# CITY OF ALBUQUERQUE

April 9, 2024

**Re: Unser Crossing**  
**Existing addresses: 8500, 8300, 8200, 8210 Central SW and 8400 Bride SW**  
**Site to be replatted to one address**  
**Traffic Overall Site Plan**  
**Architect's Stamp -no stamp- (K10D045C)**

12 BIKE RACK  
N.T.S

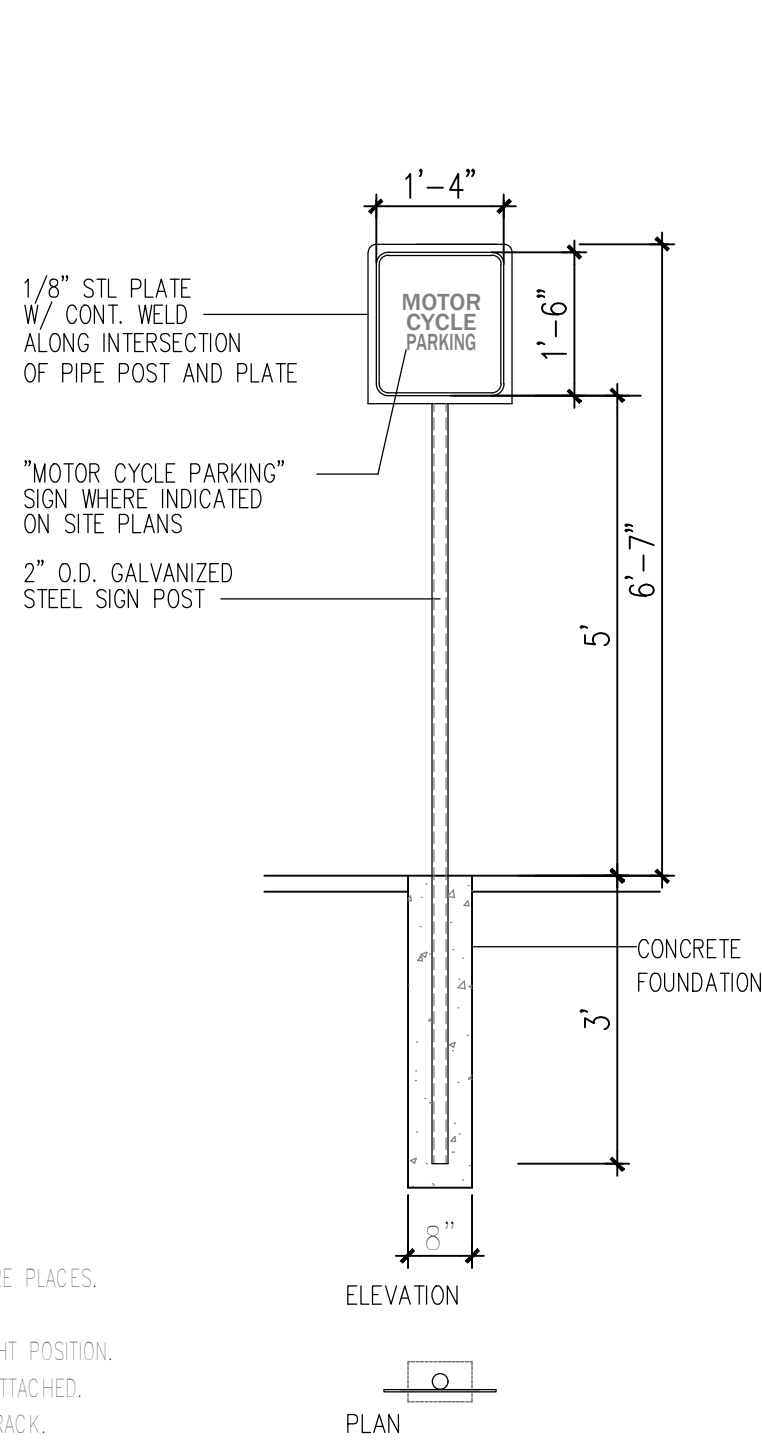
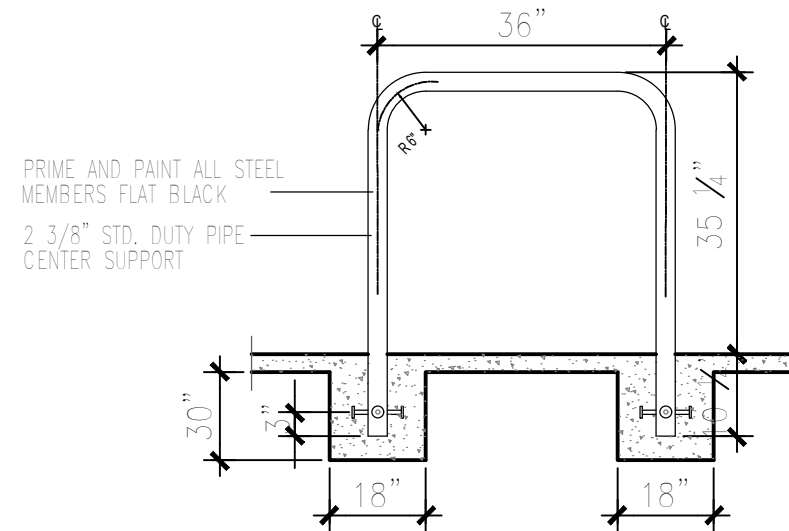
27. Comments on Detail Sheets G4 and G5:
  - a. Provide a bike rack layout that include all racks.
  - b. The ramp shown in 13/G5 may not provide enough room for a minimum 5'x5' landing. The sidewalk would need to be 10 ft wide.

3 H.C PARKING PLAN DETAIL  
N.T.S

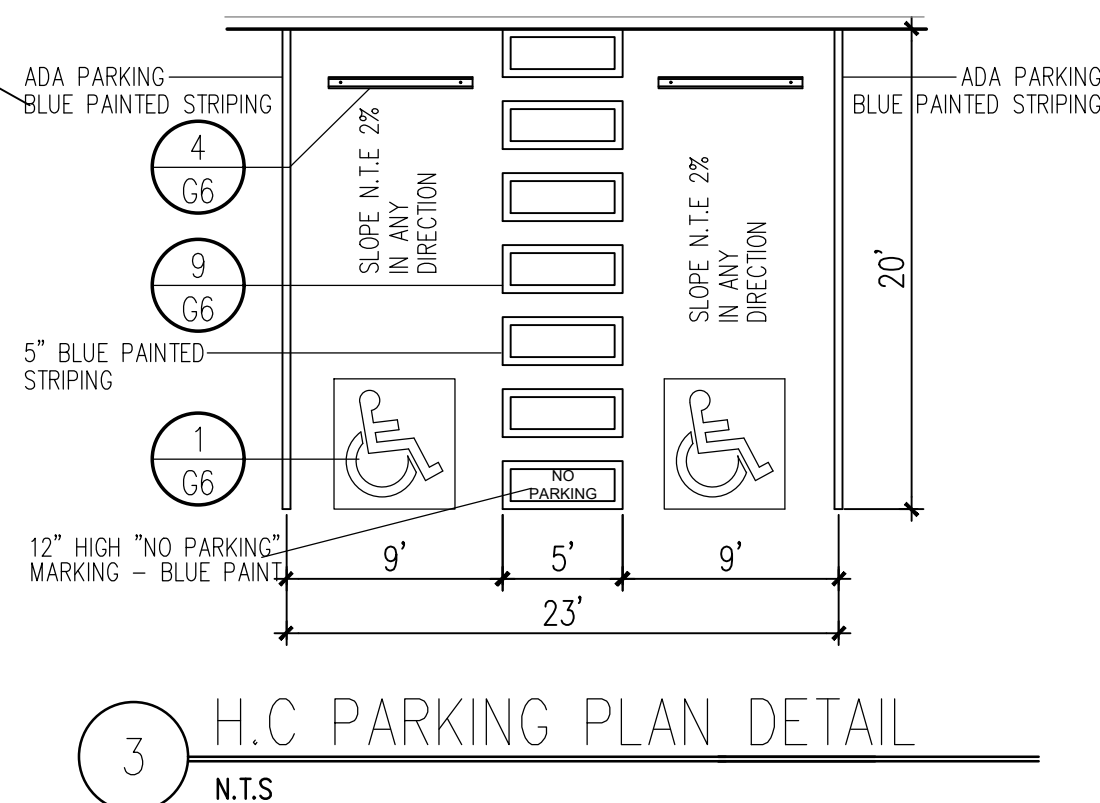
- c. Tampered Ramp Detail, 14/G5 shows a 1:20 max/ The max slope for landings is 1:50 or 2.0% in all directions.
  - d. Accessible aisles are to have blue diagonal striping, rather than the rectangles.

PROJECT TITLE	UNGER CROSSING	DRAWN BY:	9
PROJECT NO.	9	JOB NO.	9
PROJECT MANAGER			
SHEET TITLE	TRAFFIC APPROVAL SITE PLAN

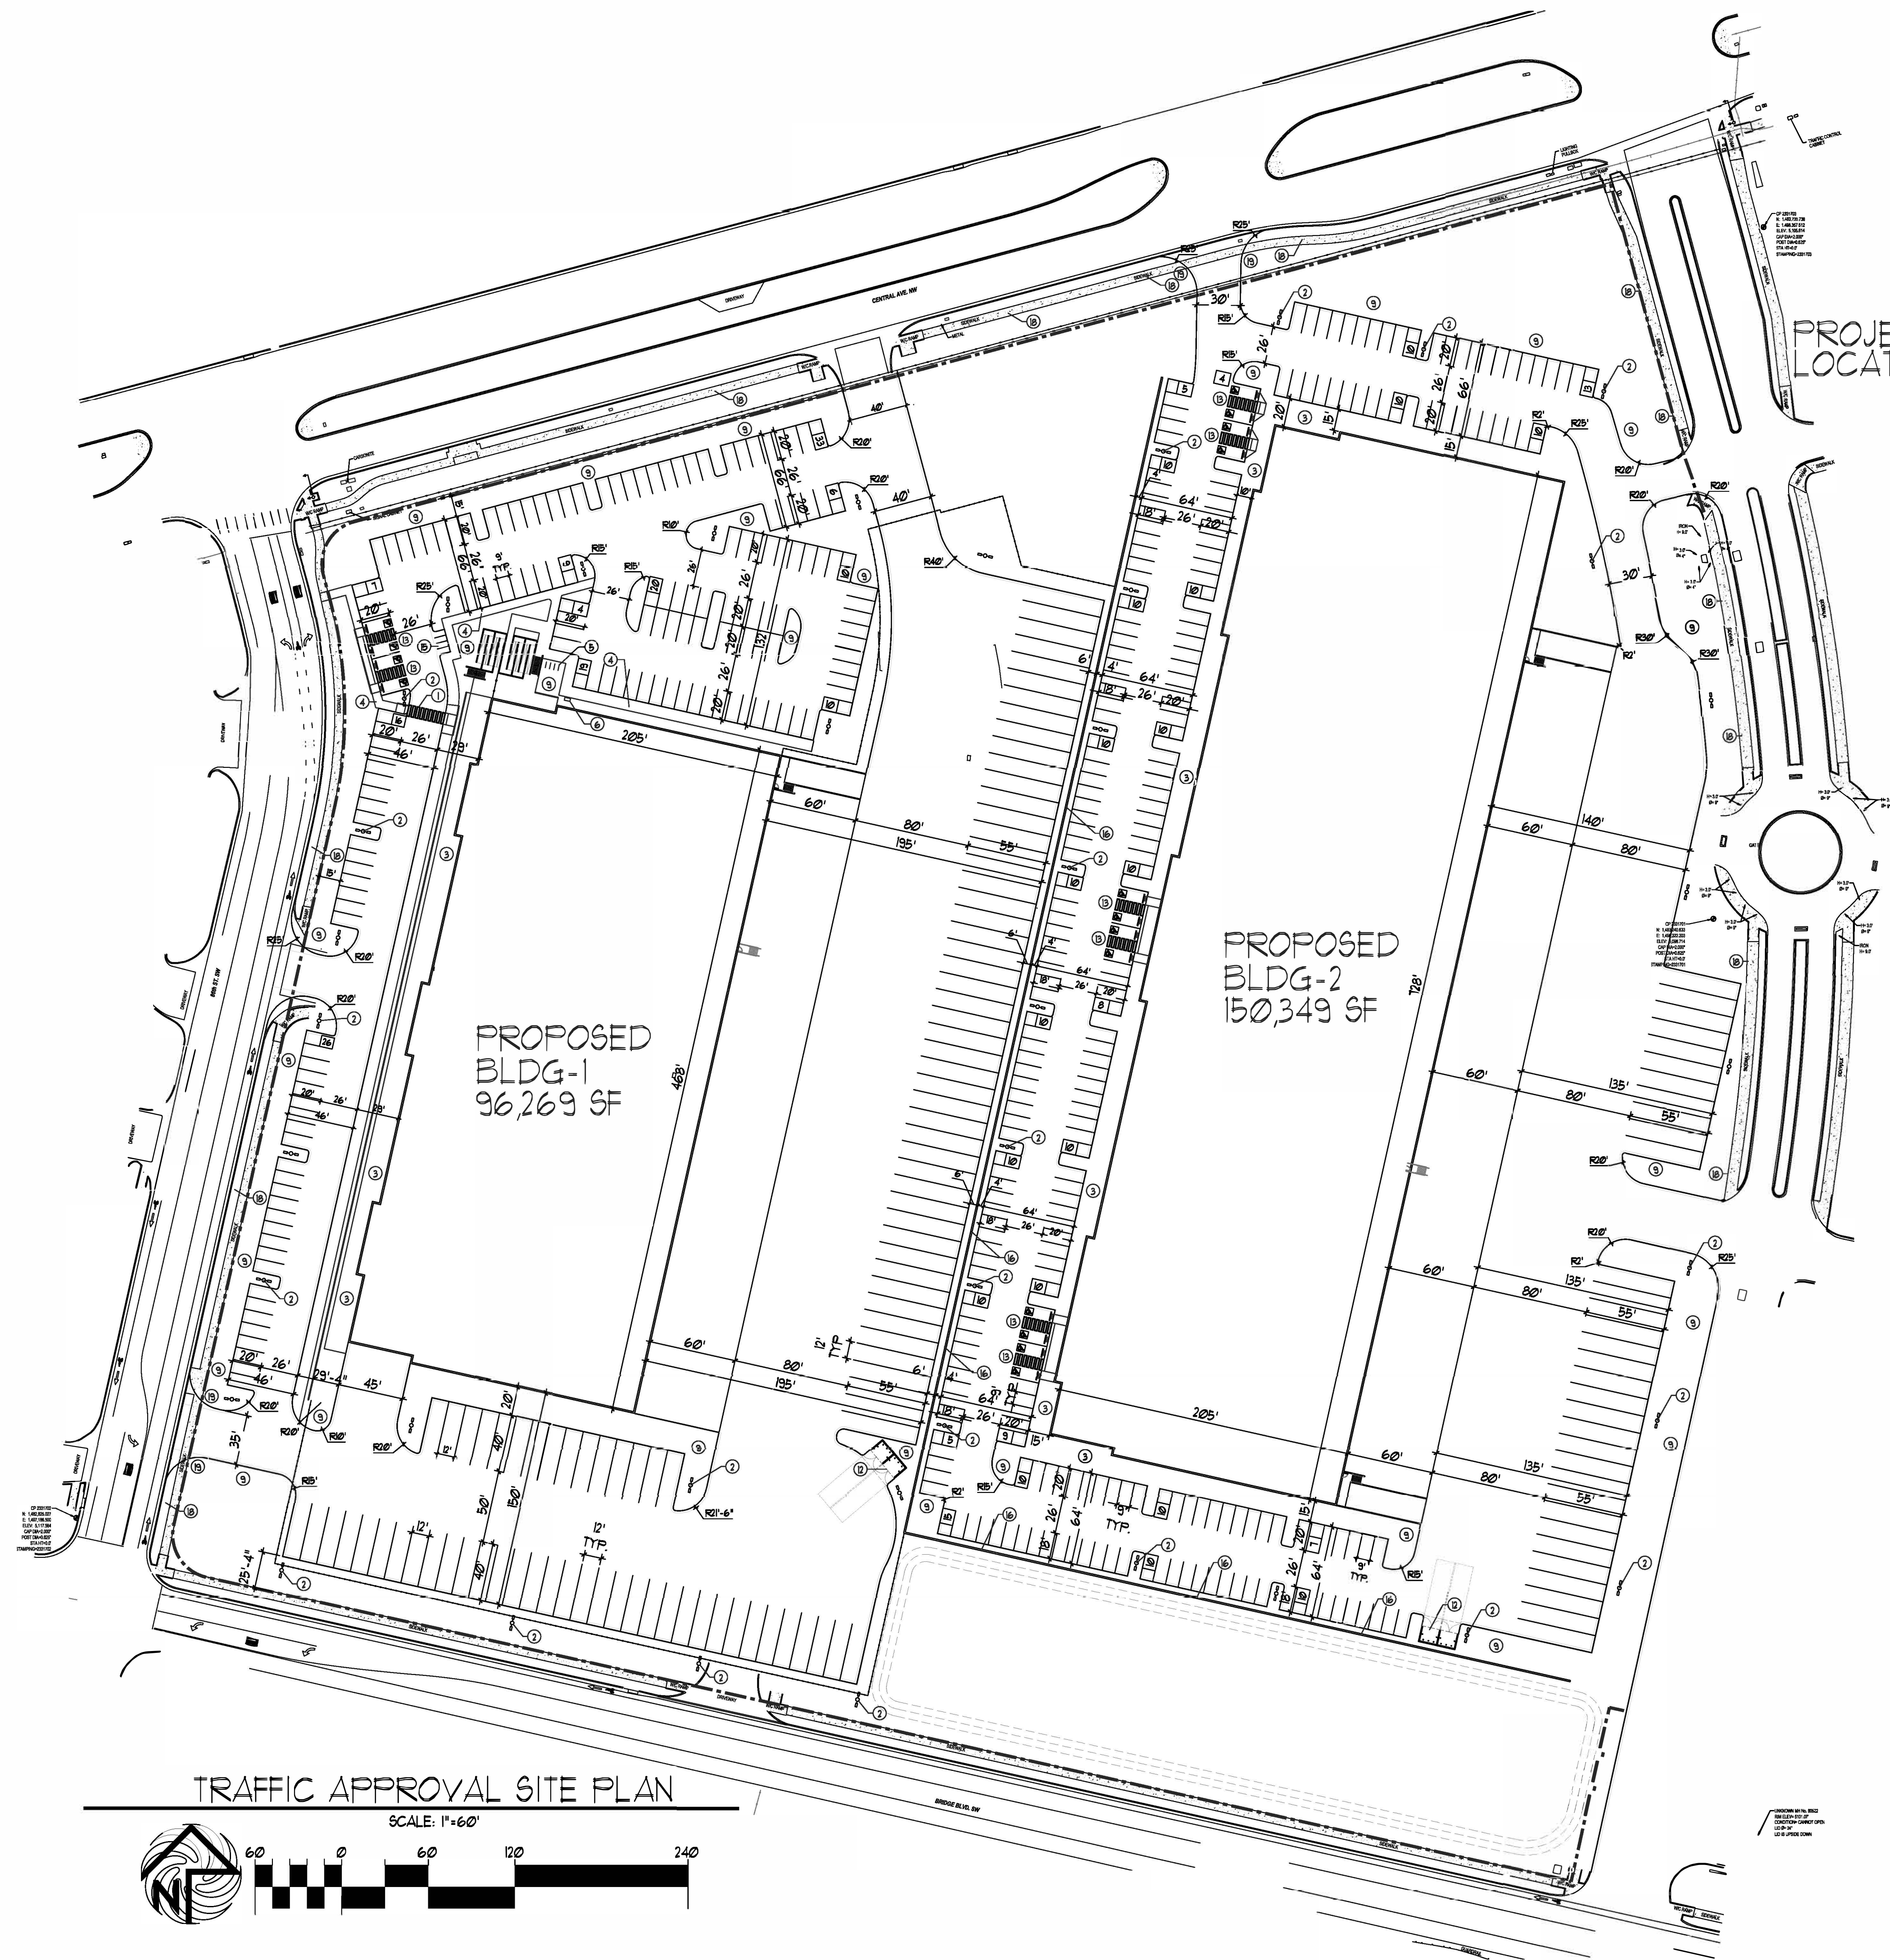
2. Show and label all existing entrances to the site off of 86<sup>th</sup> St, Central Ave, and Victory Lane.
3. Unused existing entrances are to be closed and curb and gutter and sidewalk constructed.

4. Provide a copy of the plat and the approved infrastructure list, if there is one, after it has been replatted.
5. There is most likely an Access Easement on Tract 12 for the benefit of the property this project is on. Victory Lane is to be constructed in the easement from the north terminus to Bridge Blvd. Provide a copy of the plat/easement. Show the proposed Victory lane extension on the plan.

6. The Long Range Bikeway System map shows a Protected Bike Lane Upgrade along the frontage of this project. Show this on the plan.
7. The Protected Bike Lane and the extension of Victory Lane are to be built per Work Order. Please add a note for this.

8. Why does the west entrance on Central Ave need to be 40 ft wide? Narrower entrances are better for pedestrians.
9. Label Victory Lane.
10. Sites are required to be paved. Specify the pavement type.

11. The Jersey Barriers in Victory Lane at the north end of the traffic circle and along Central Ave are to be removed.
12. Radii of 20' for the entrance off of Victory Lane are not large enough for vehicles SU-30 and larger. Specify expected largest vehicle and provide appropriate radii.

13. Is it necessary to have connectivity between the warehouse delivery circulation and passenger vehicle circulation?
14. Provide the location of the office front door(s) for both buildings.

15. Specify the width of existing sidewalks on Central Ave, Bridge Blvd and Victory Lane.

16. The plan is to be stamped/sealed.

17. The sidewalk disappears at the traffic circle.
18. Draw the mini clear sight triangles at all of the site entrances.
19. Provide build notes for curb and gutter, ramps, drive entrances and all sidewalk widths.

20. I couldn't find the motorcycle and bicycle parking spaces for Bldg. 2.
21. Specify radii for all parking islands.
22. I couldn't find the location for the bollards (Keyed Note 20).

23. Provide all site entrance widths.
24. Provide Fire and Solid Waste Dept. approvals.
25. Provide dimensions for motorcycle parking stalls.
26. I couldn't find the locations for Keyed Notes 7 and 8.
